TO: Jacob Dalton
PROJECT #: 22-1659-A
PAGE: 1 of 3
DATE: November 19, 2024
LOCATION: Dalton Residence Yellow Brick Road, Pittsboro
PLAN REF: Dalton Residence by Diane Rives Design
Project# 22-1659

THE FOLLOWING CHANGE(S) OR PROPOSED CHANGE(S) LISTED BELOW ARE DEVIATIONS OR CLARIFICATIONS FOR THE ABOVE REFERENCED PLANS:

FIRST FLOOR STRUCTURAL PLAN  
SCALE: 3/16" = 1'-0"  
REFER TO "SD" SHEET(S) FOR STANDARD DETAILS AND STRUCTURAL NOTES

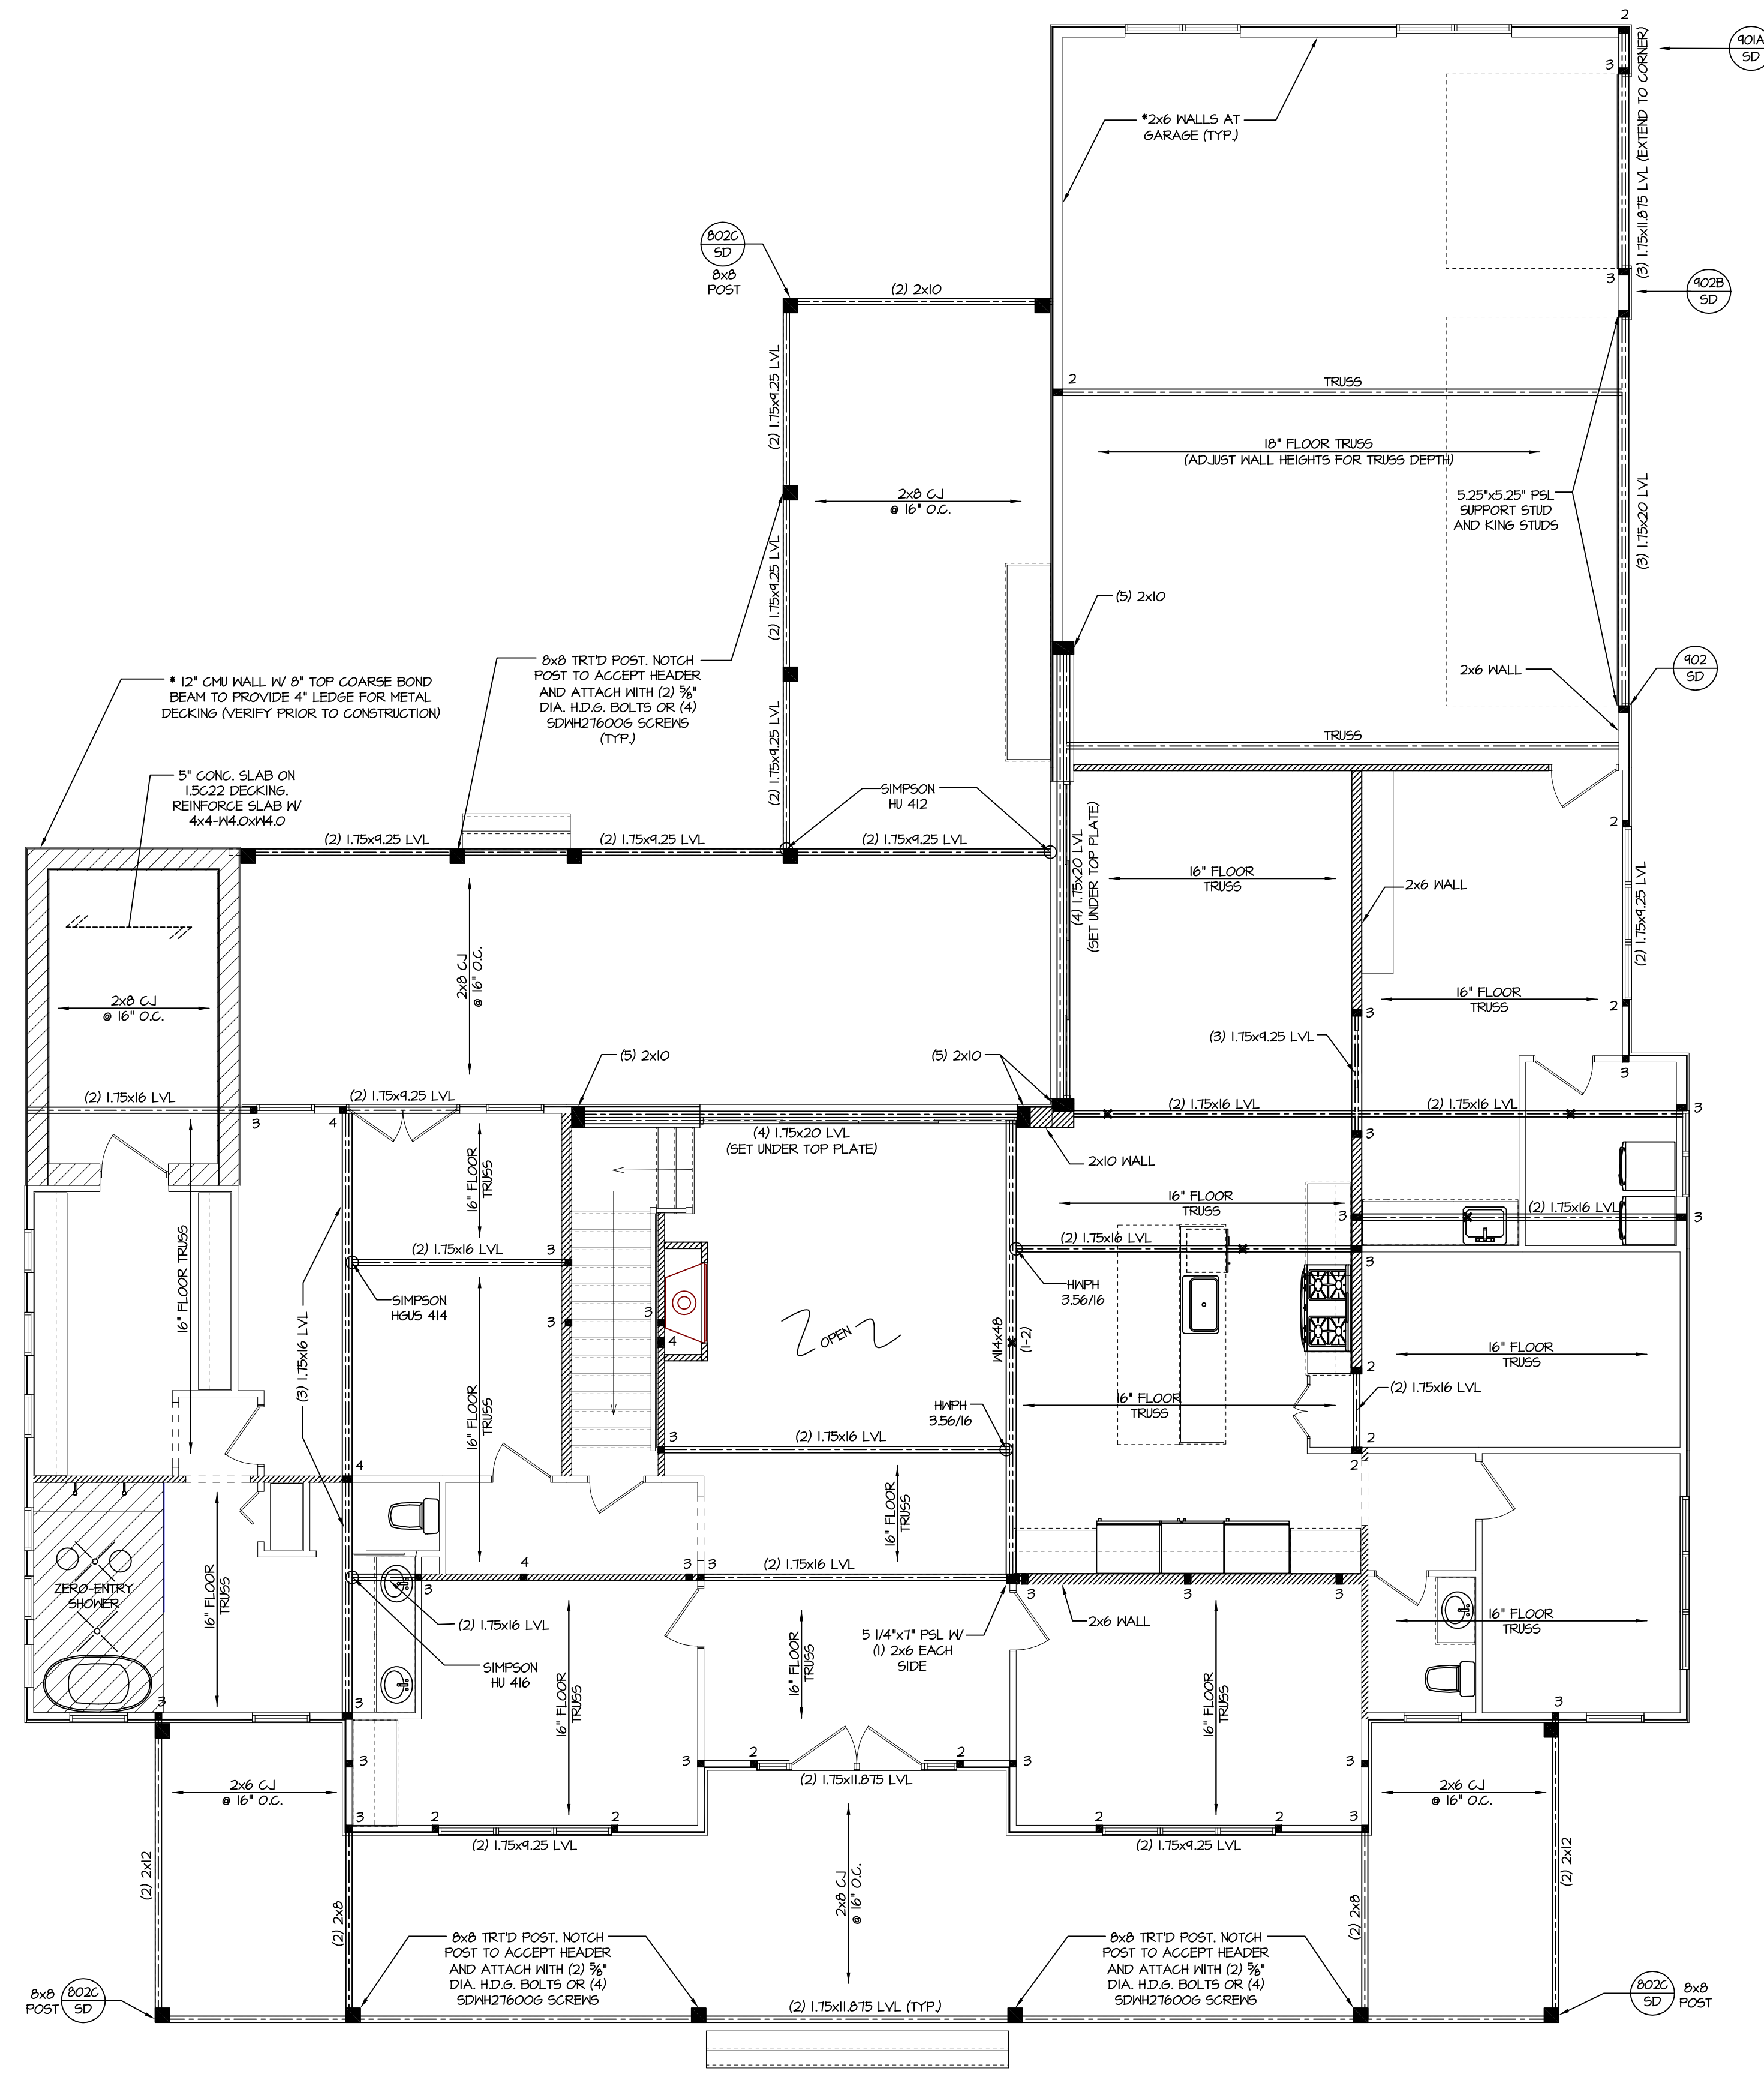
B. Safe Room Ceiling: The original plans specify the ceiling in the safe room to be constructed with 2 x 8 ceiling joists running left to right. Per information provided by the builder the ceiling was constructed with 2 x 6 ceiling joists running forward to back. The ceiling joists at the (2) 1.75 x 16" LVL are attached to a ledger.

C. Chimney Box-Out and HVAC Return: The original plans specify that the chimney box-out in the Family Room should be constructed using (2) 2 x 8s. Per information provided by the builder, an additional box-out was created for an HVAC return. The chimney box-out was built using the extended (3) 1.75 x 14" LVL in the family room, a (3) 2 x 8 attached to the extended LVL, and a (1) 2 x 8 attached to the (3) 2 x 8. The HVAC return box-out was constructed with a (3) 2 x 8 connected to a (1) 2 x 8 on both sides. The (1) 2 x 8 connected to the (3) 2 x 8 is connected to another (1) 2 x 8.

D. LVL Shift and LVL Omission: Per information provided by the builder the (3) 1.75 x 14" LVL in the Family Room was shifted to be about 8' from the slider door. The (3) 1.75 x 14" LVL was run long over the stairs. This extension made the (2) 1.75 x 9.25" LVL originally designed to go over the stairs obsolete. The shifted (3) 1.75 x 14" LVL that was shifted is supported by (4) 2 x 4 stud columns that hit over the triple joist and double joist in the crawl space as indicated in the image below.

Response: Please note the ceiling construction described above is acceptable.

Response: Please note the box outs described above are acceptable.

Response: Please note that the LVL shift, extension and the omission of the LVL over the stairs as described above is acceptable provided that the double joist and triple joist in the crawl space have a (1) 1.75 x 9.25 LVL attached with (3) 10d nails every 6" to each side of the double and triple joists.

**SECOND FLOOR STRUCTURAL PLAN**  
SCALE: 3/16" = 1'-0"  
REFER TO "SD" SHEET(S) FOR STANDARD DETAILS AND STRUCTURAL NOTES

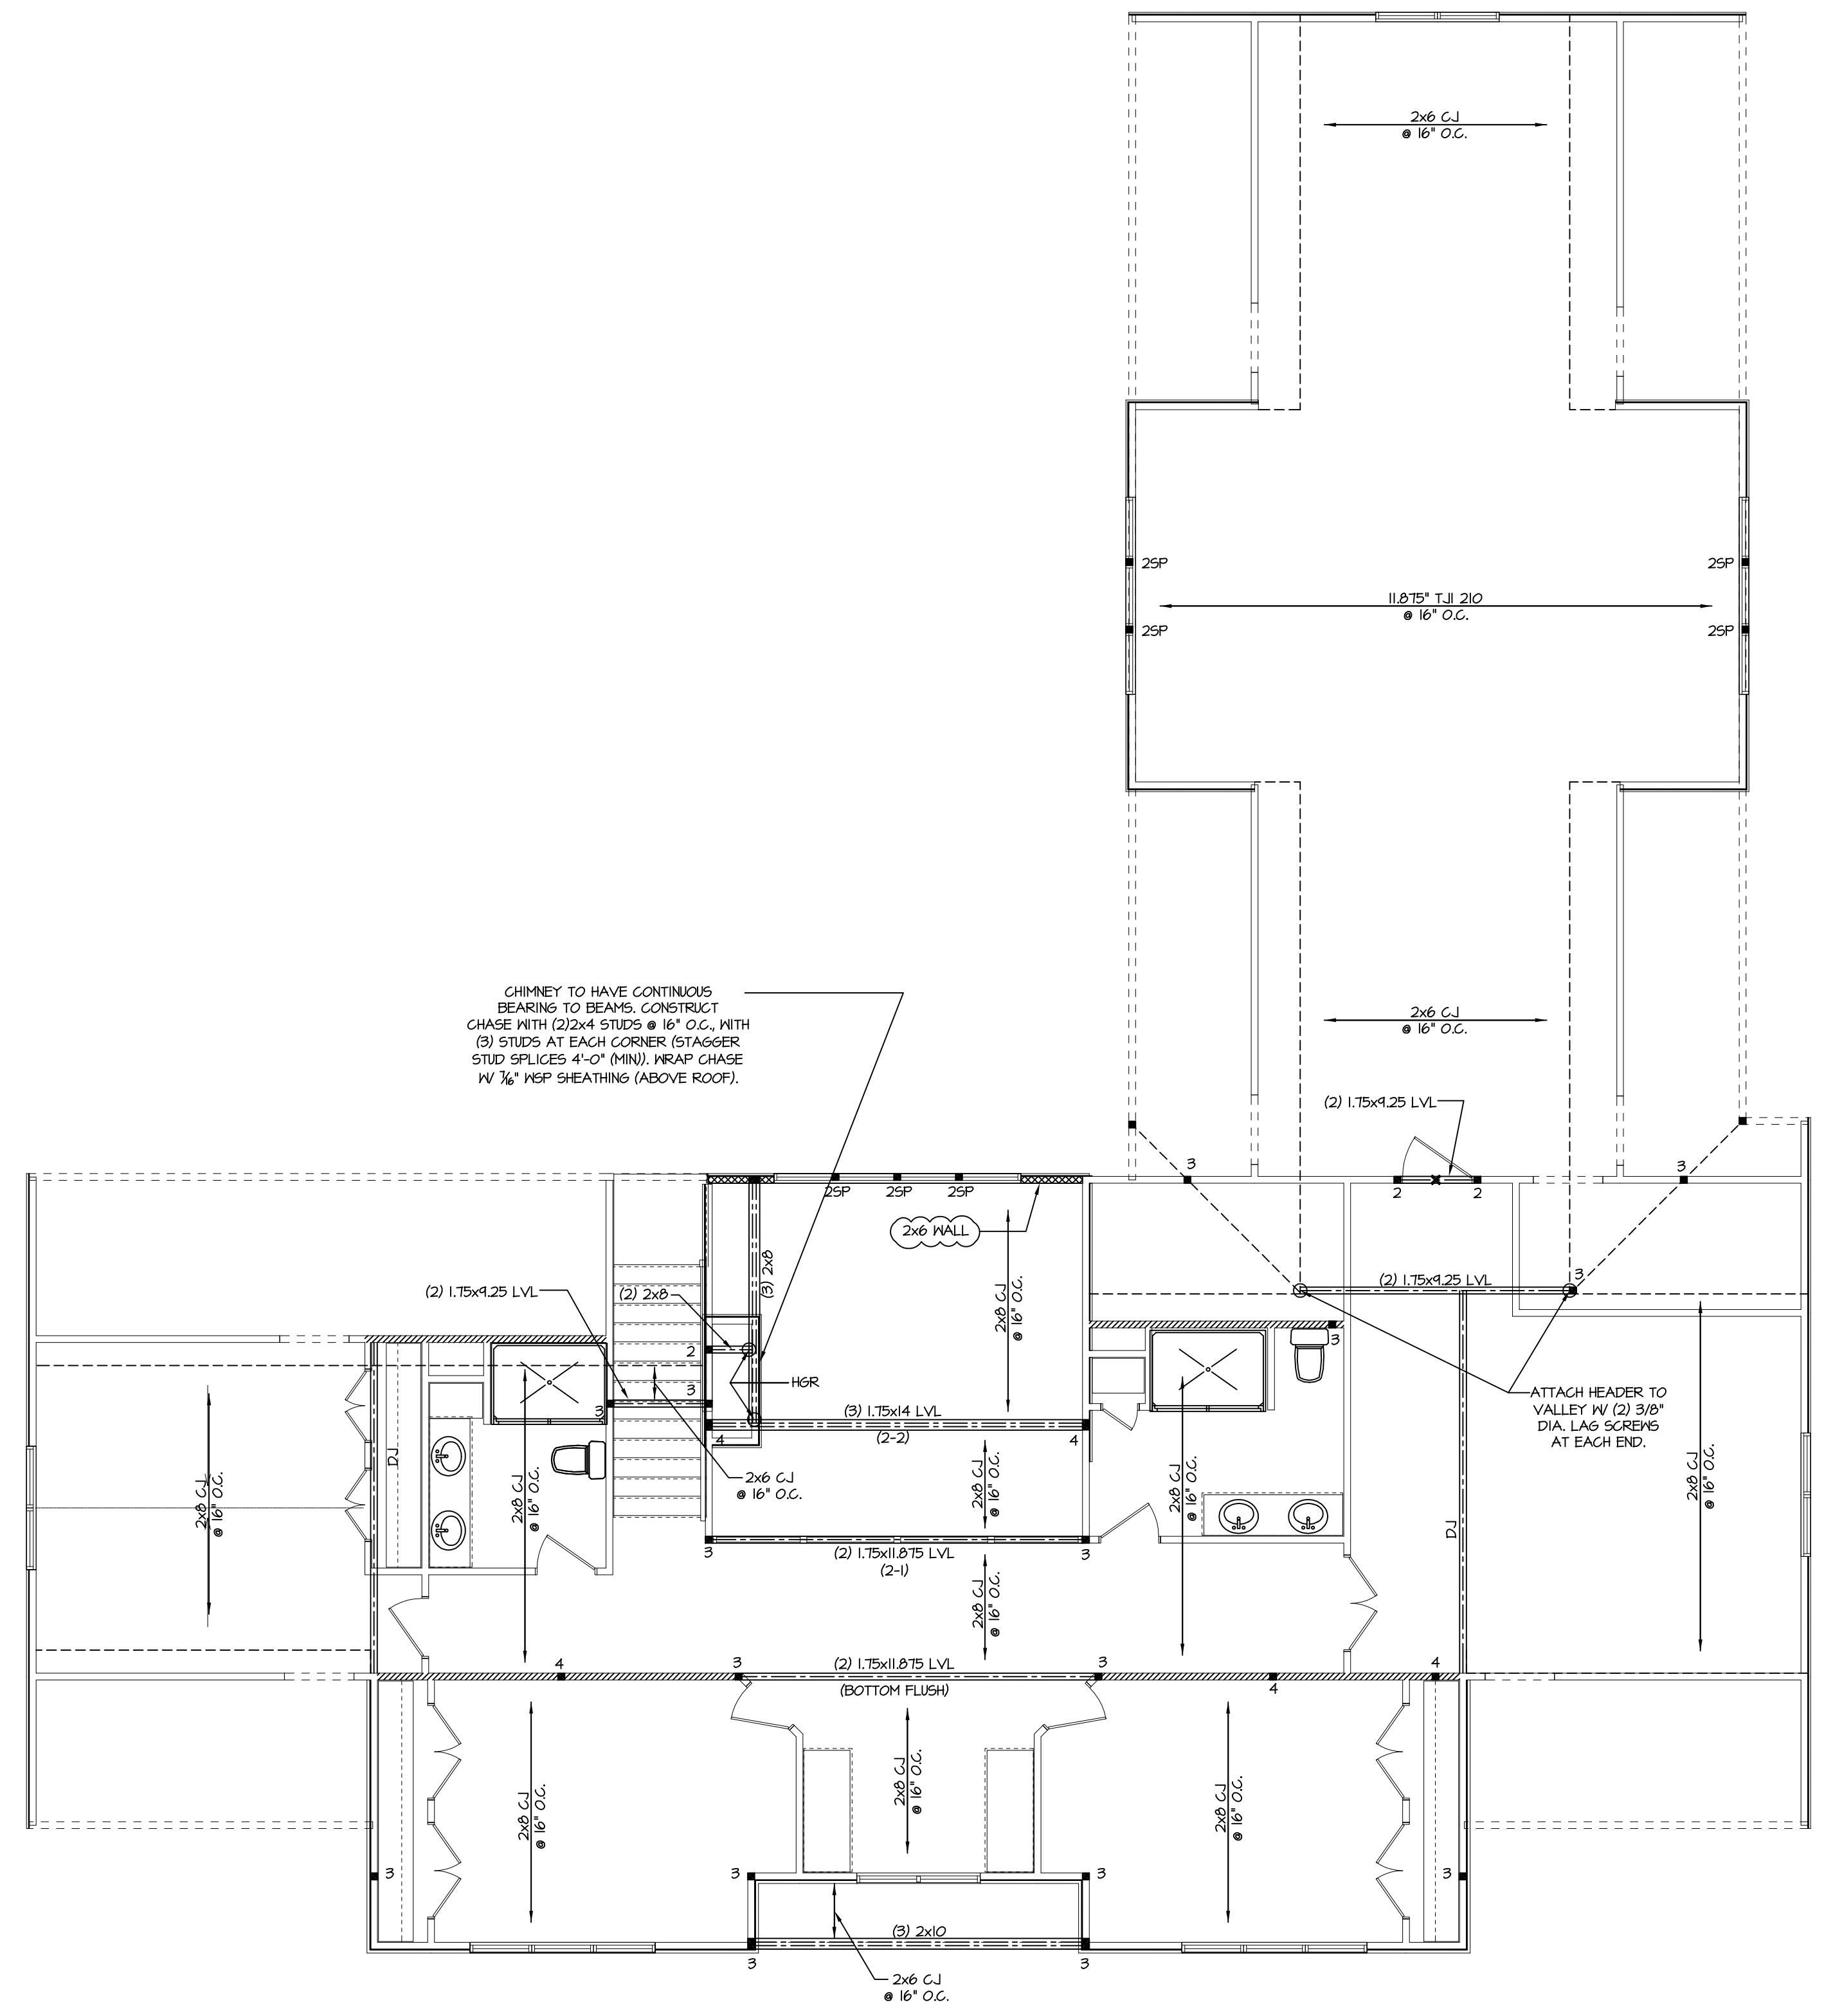
E. LVL Header and Valley shift: The original plans specify the (2) 1.75 x 9.25 to attach to the valleys with (2) 3/8" diameter lag screws and be supported with a (3) 2 x 4 stud column. Per information gathered on a site observation on 11/14/24 the (2) 1.75 x 9.25" LVL was shifted forward to match the shift from the (2) 1.75 x 9.25" LVL valley above. The shift now has the valley supported by (3) 2 x 4 stud column in the wall on the right and a (3) 2 x 4 stud column in the bathroom wall on the left. The (3) 2 x 4 stud columns on each side are supported by the (2) 1.75 x 16" LVLs below. Please refer to the image below to visualize the shift from the (2) 1.75 x 9.25" LVL header and valley.

Response: Please note the LVL header and LVL Valley shift described above is acceptable.
